Our Reference: SYD13/01444/03 (A9876085)
DP&I Ref: SSD 6324

**RESPONSE TO SUBMISSIONS FOR BRINGELLY ROAD BUSINESS HUB
BRINGELLY ROAD, LEPPINGTON**

Rachel Nicholson
A/Senior Land Use Planner
Network and Safety Section

SUBDIVISION OF LAND IN C.OF T. VOL:1151 FOL:236

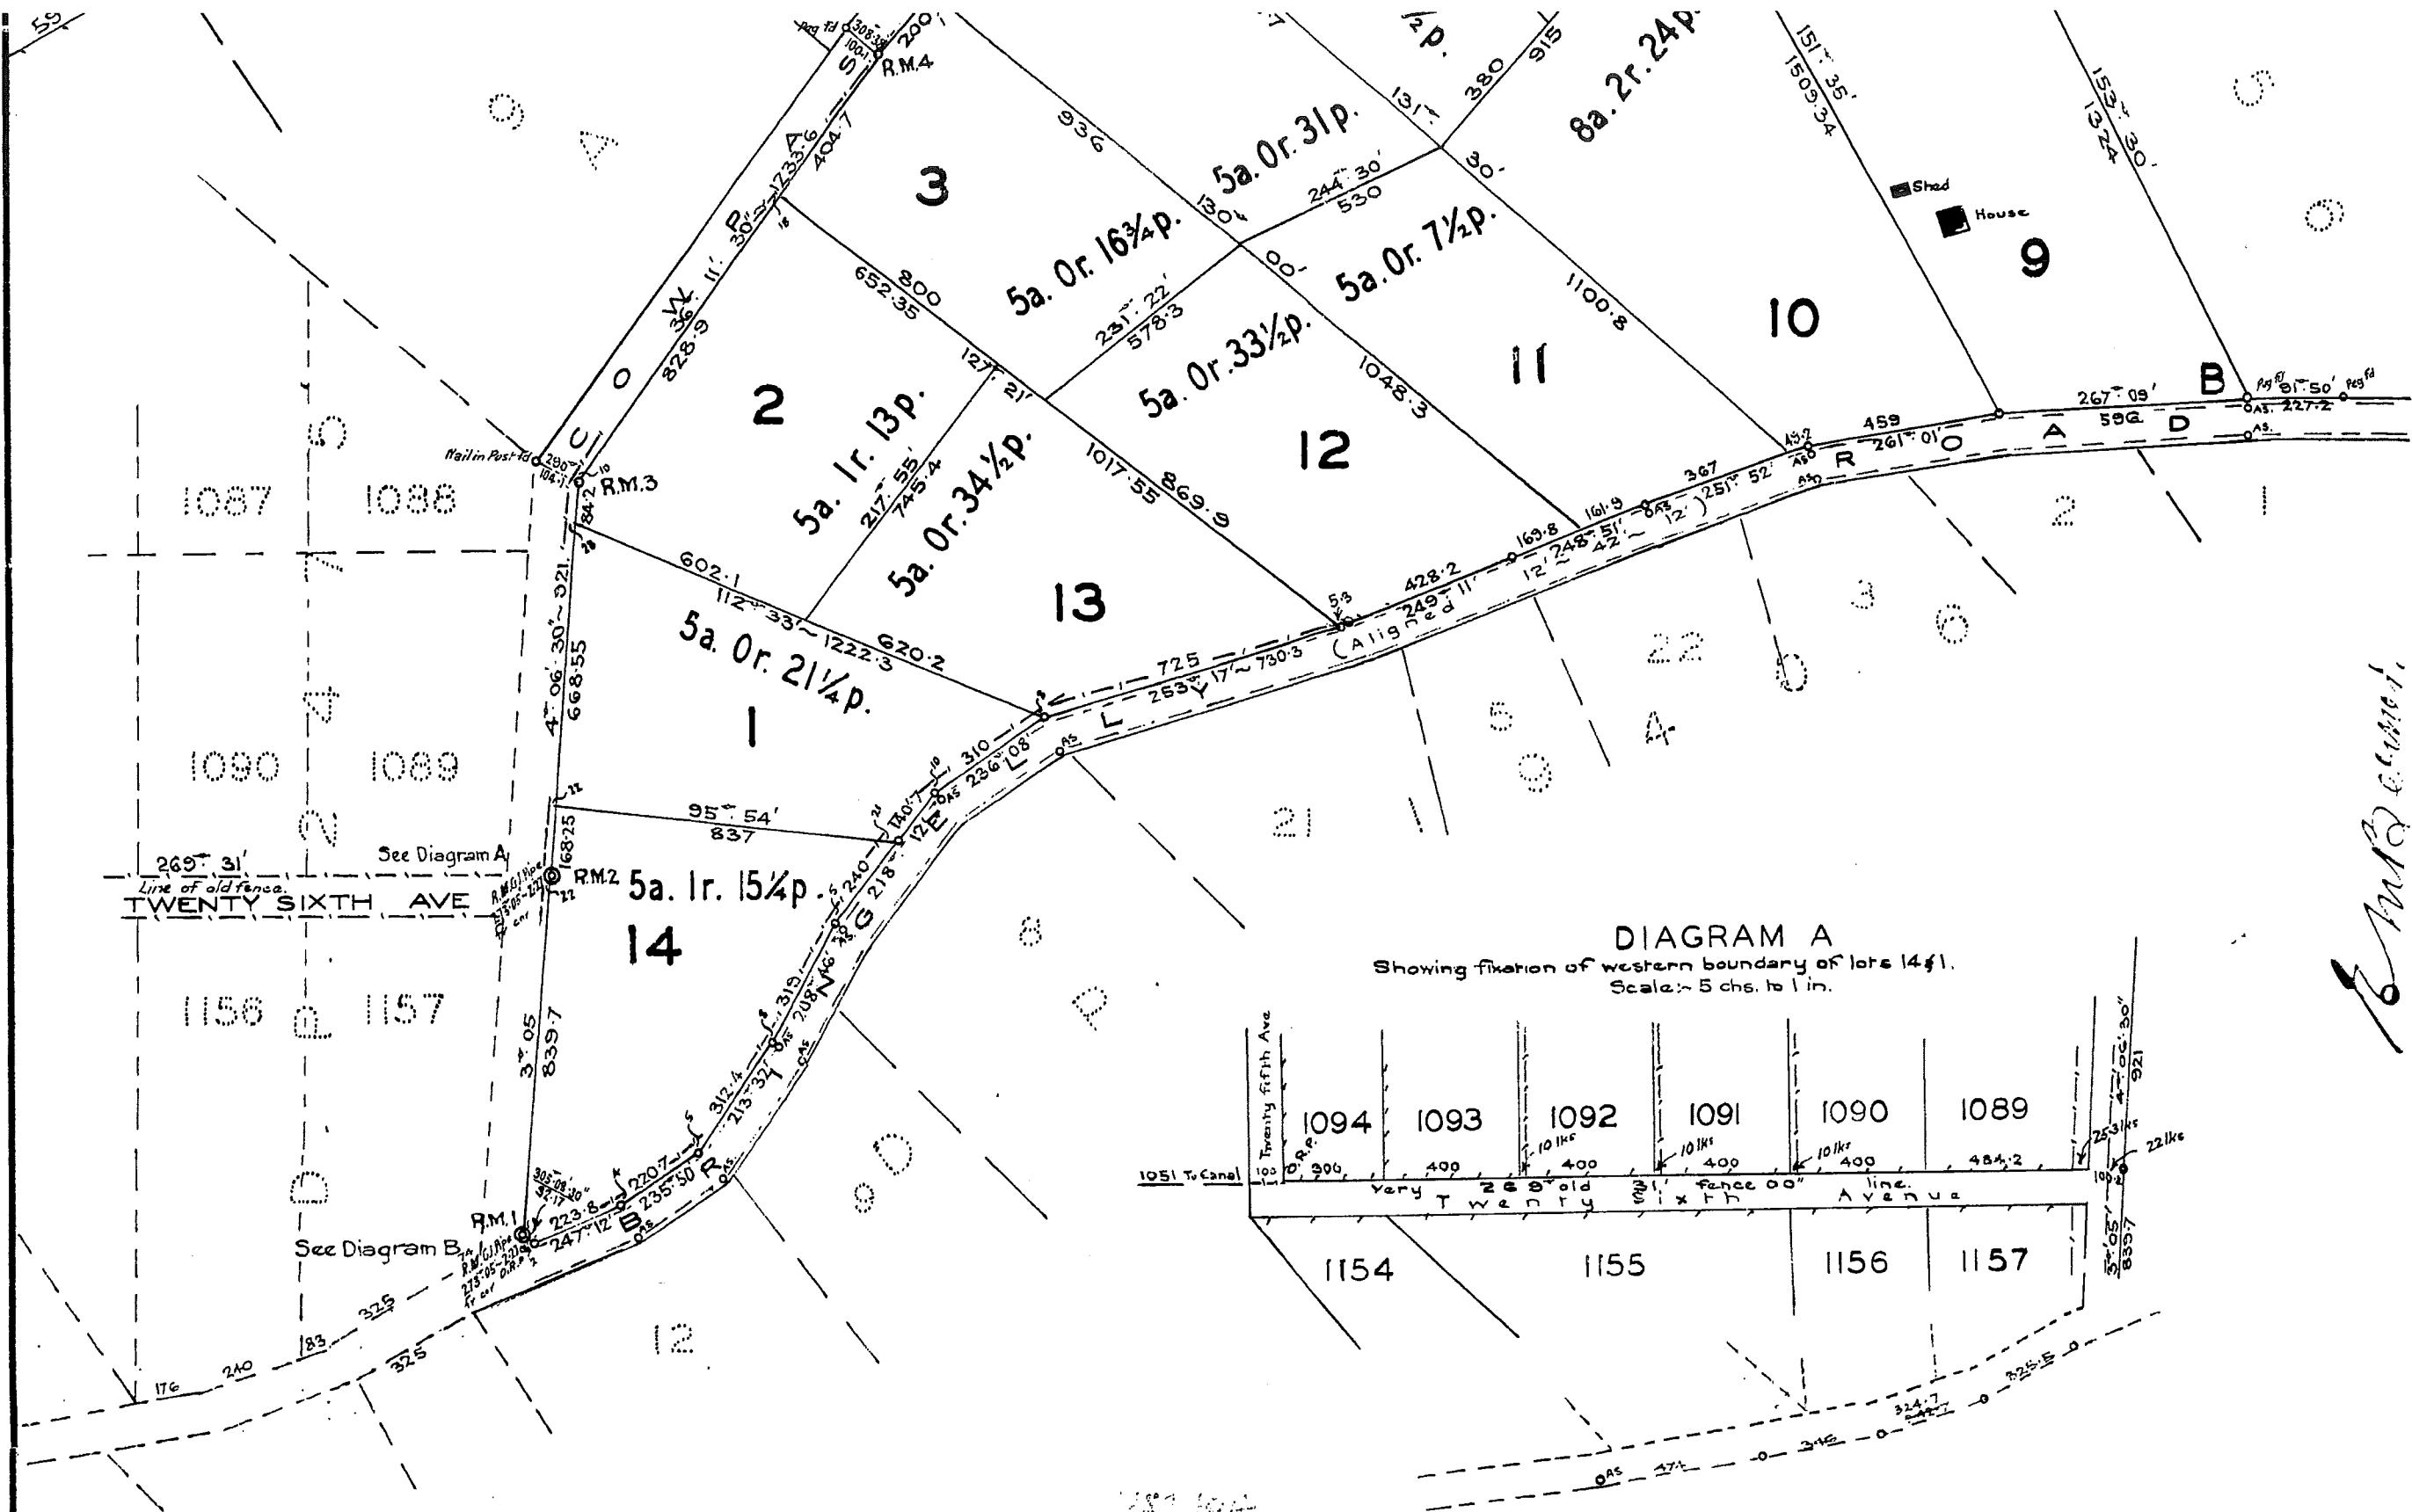
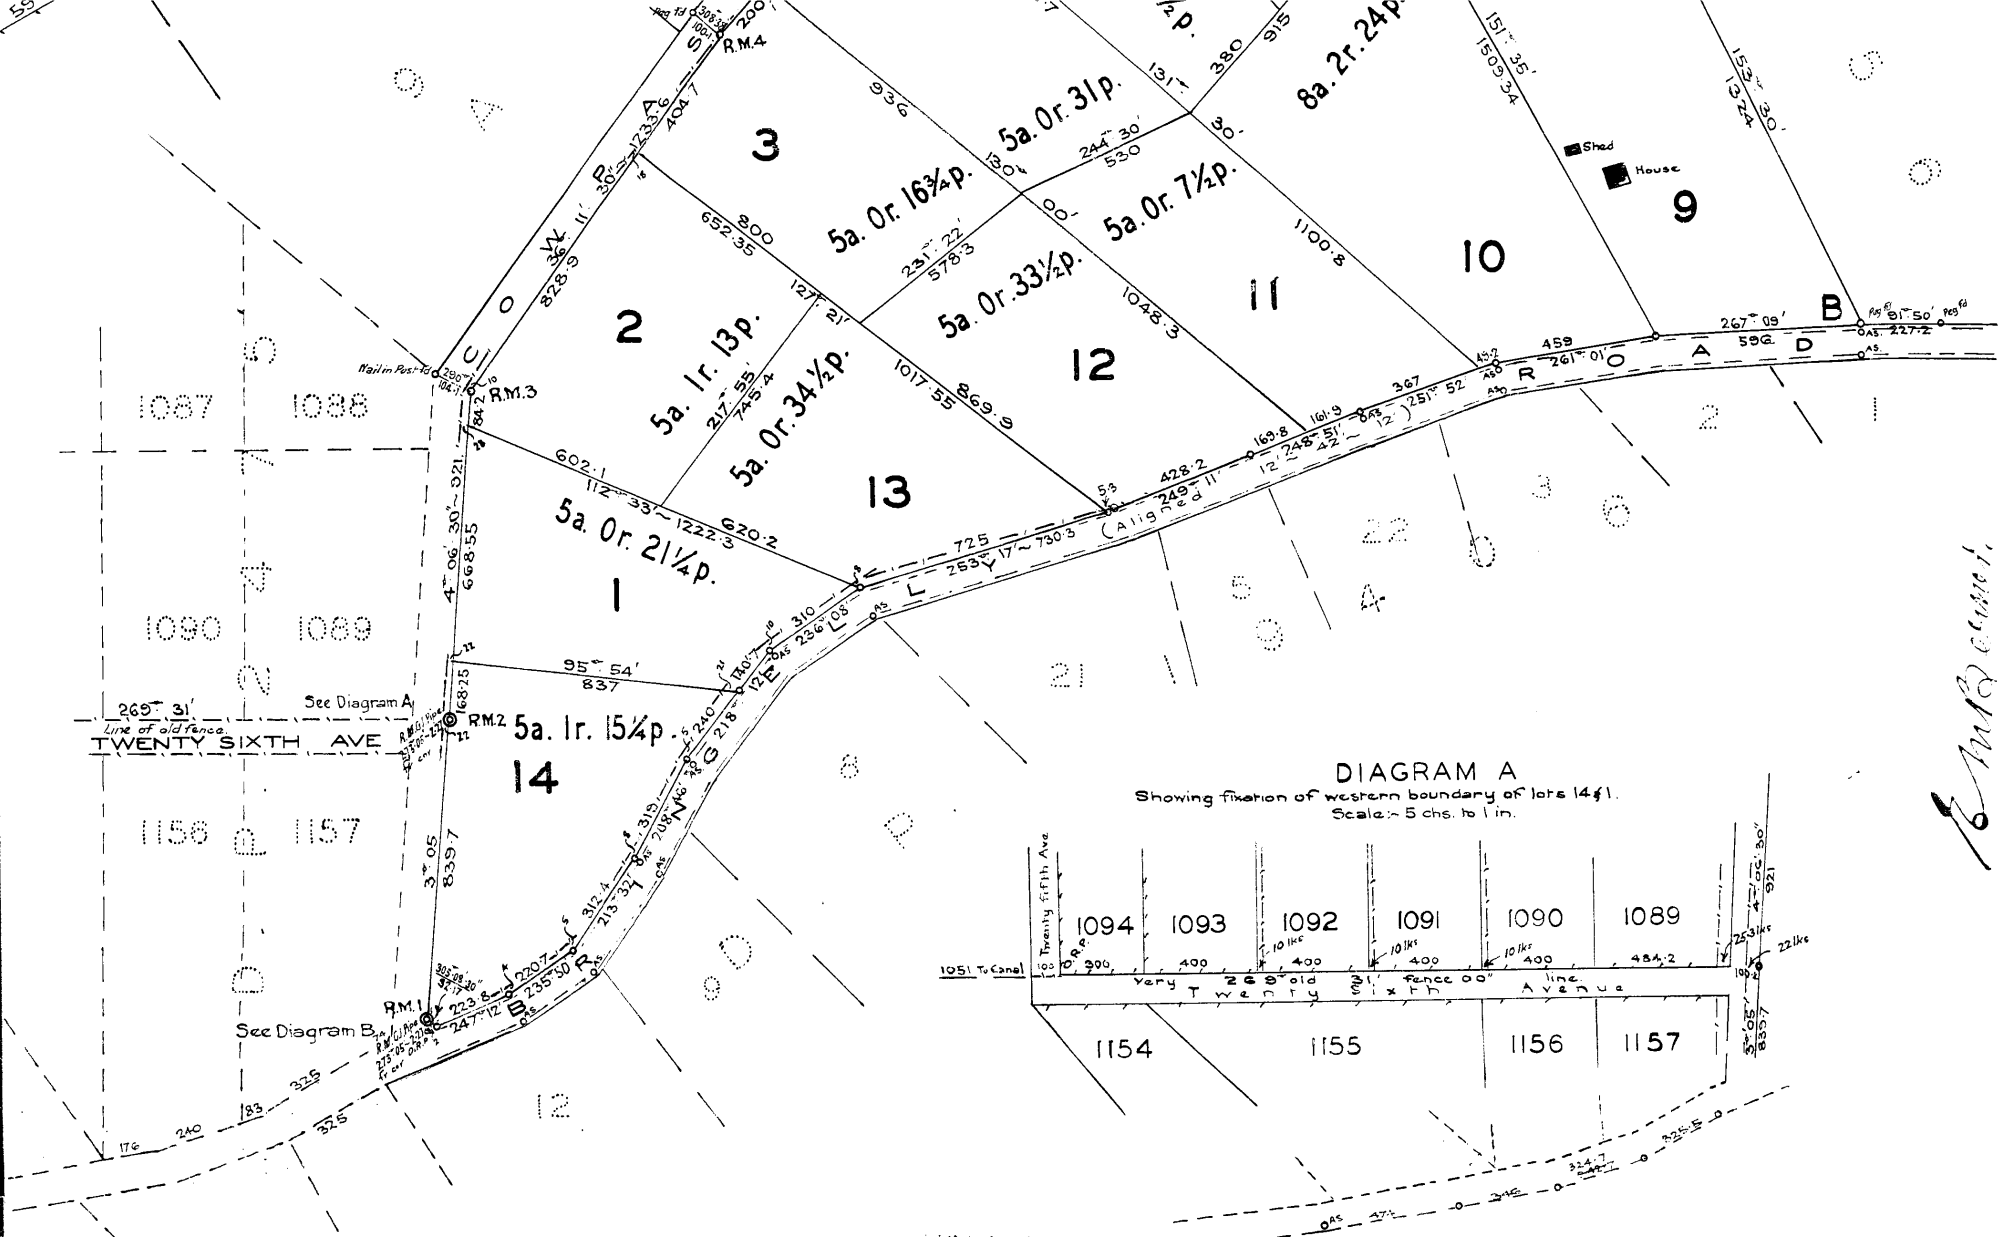
2. Roads and Maritime now understands that Lot 9 DP 29104 is in separate ownership and does not form part of the proposed subdivision. Given this, Road and Maritime maintains that the proposed truck lane should be extended along the rear of Lots 6 and 8 to provide separate delivery vehicle access, however, Roads and Maritime does not require this to extend across Lot 9 to connect to Cowpasture Road.

3. It is understood that future access to Lot 9 DP 29104 will be obtained via the proposed internal road. In this regard, the proposed future extension of the internal Road to facilitate future access to Lot 9 should be legally certified on the titles of the burdened lot/s (proposed Lot 9) via a "Right of Way" prior to a subdivision certificate being issued by way of a Section 88B Instrument under the Conveyancing Act, 1919 to secure this future access.
